Attn.: Mr. Brad Walters, Inspection Supervisor
RE: Cloverleaf Filing No. 2 – Pond Certifications

This letter is intended to provide documentation with County Inspection Staff that the Pond facilities in Cloverleaf Filing No. 2 have been constructed within reasonable conformance to the design. The District owned pond facilities for Cloverleaf Filing No. 2 are described by the following:

POND 4 - PLAN

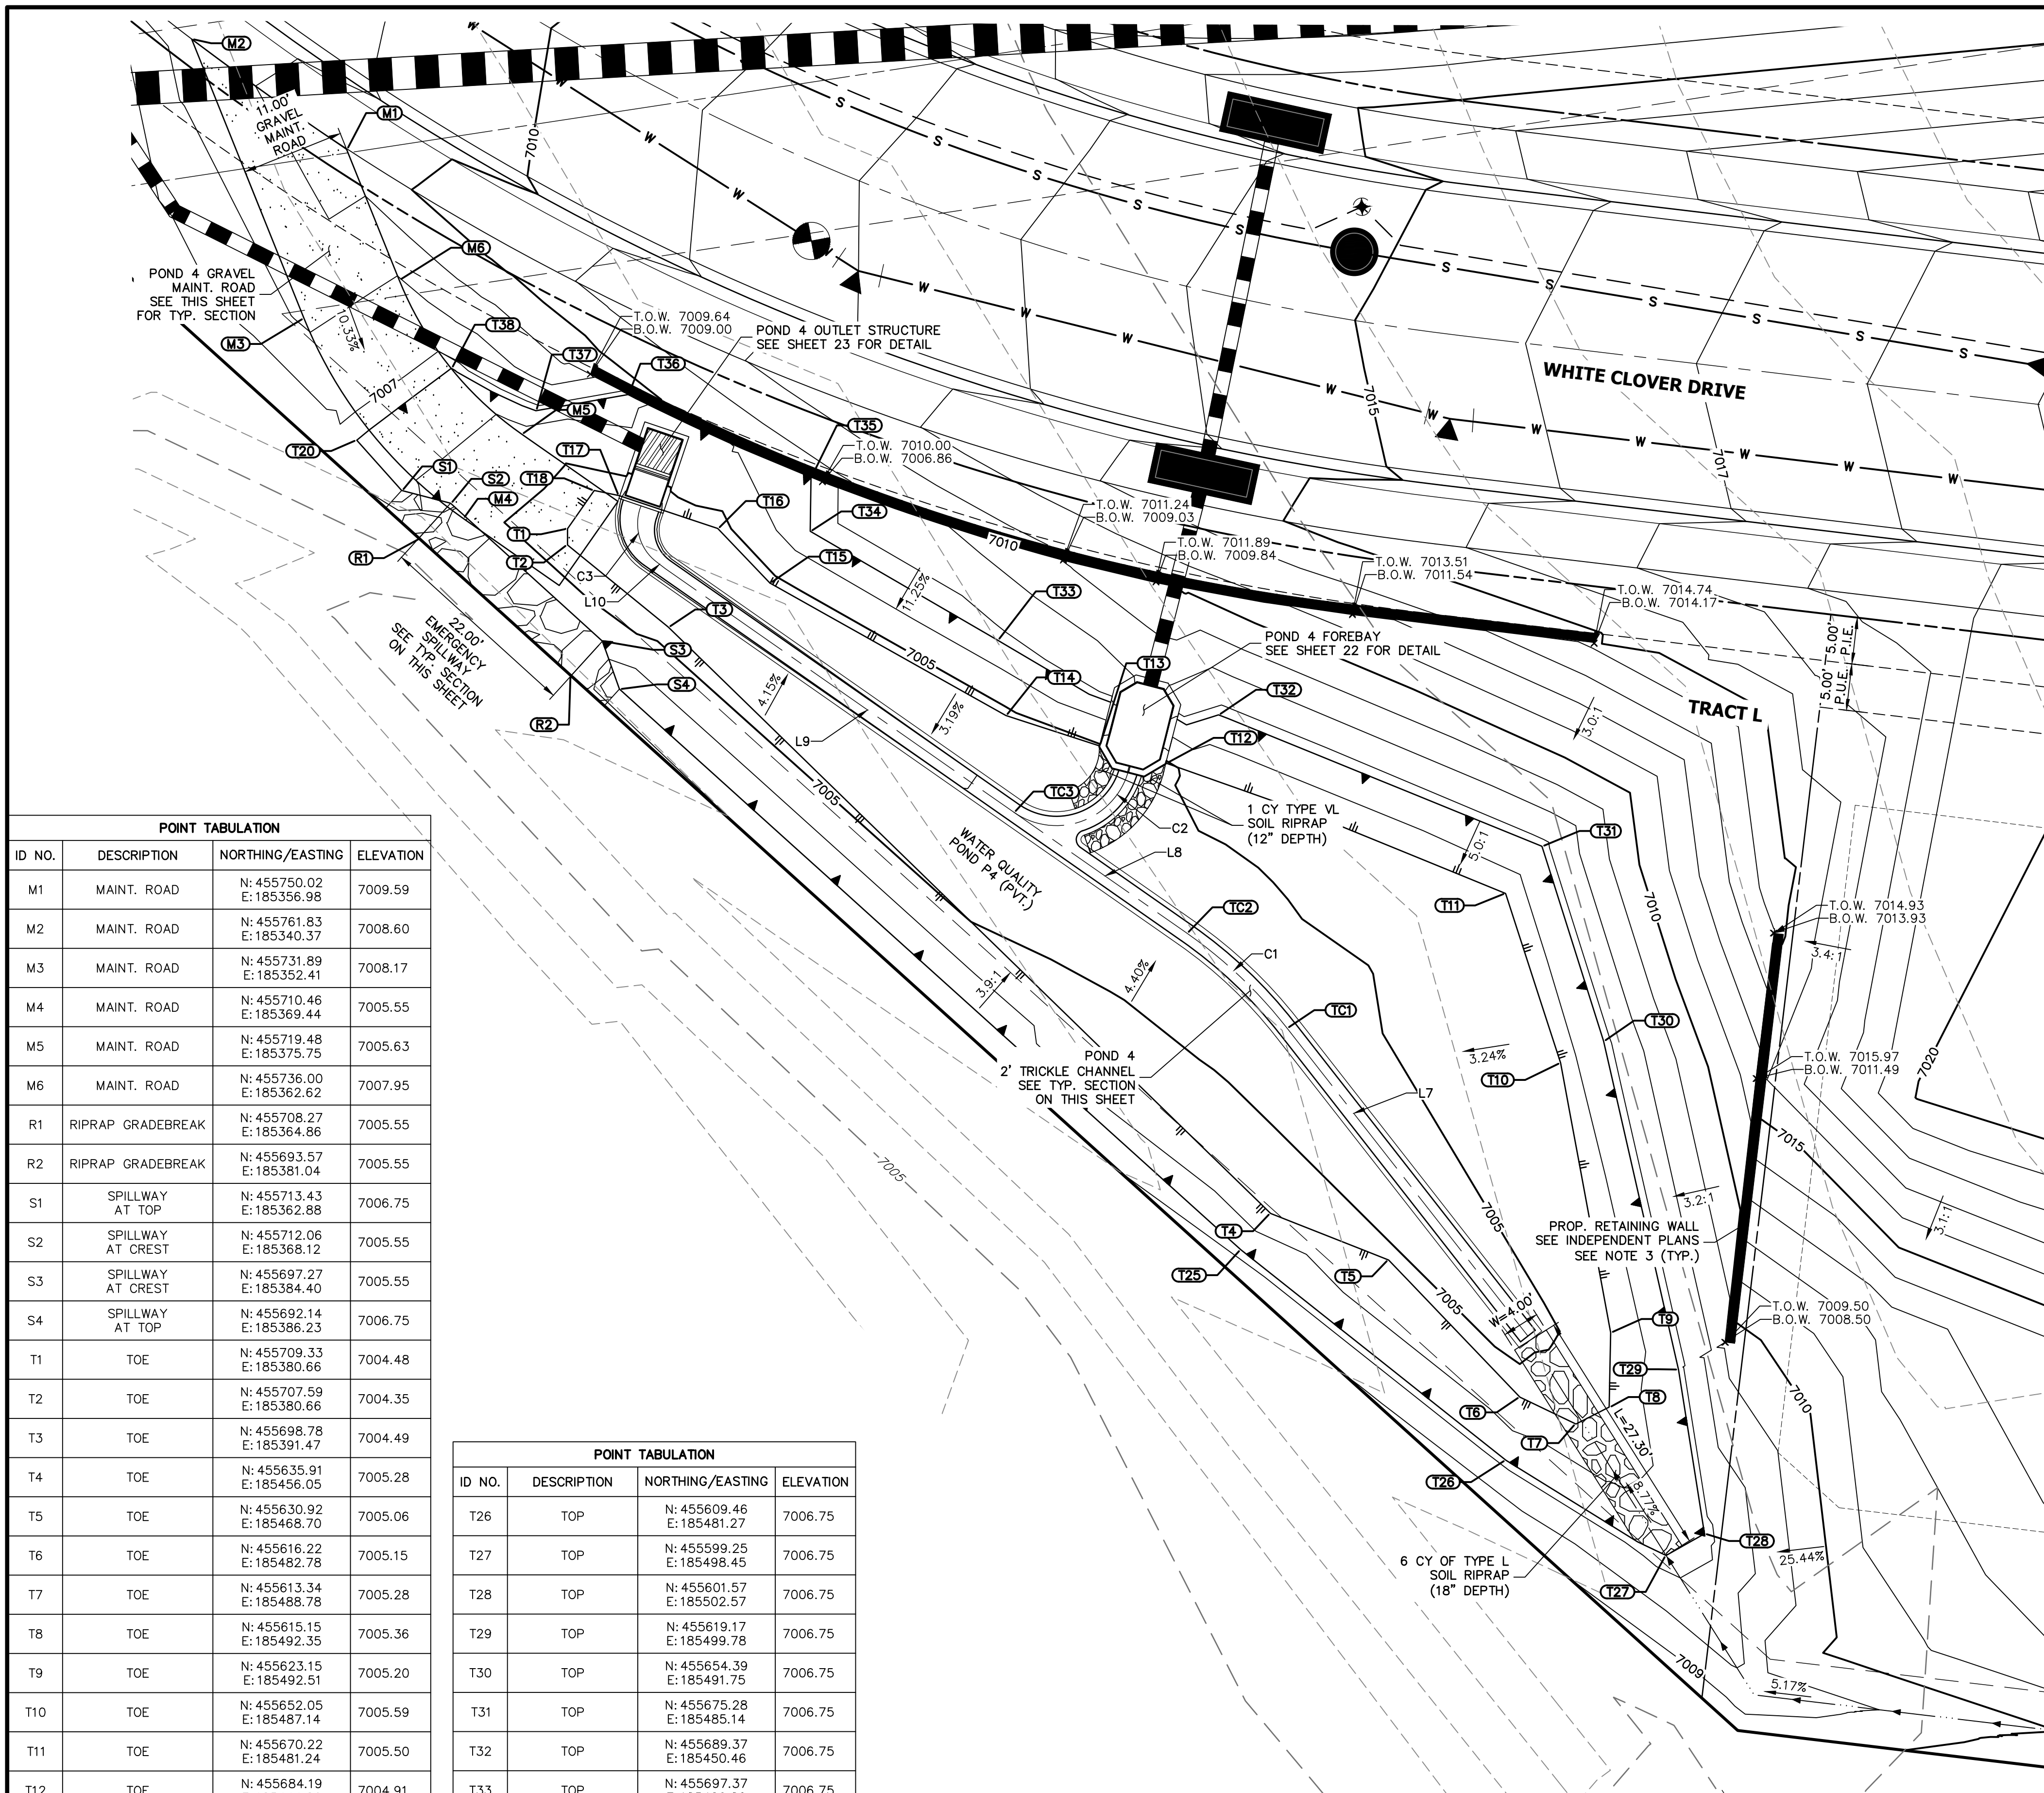
should be yellow and 6.97 per Sht 16
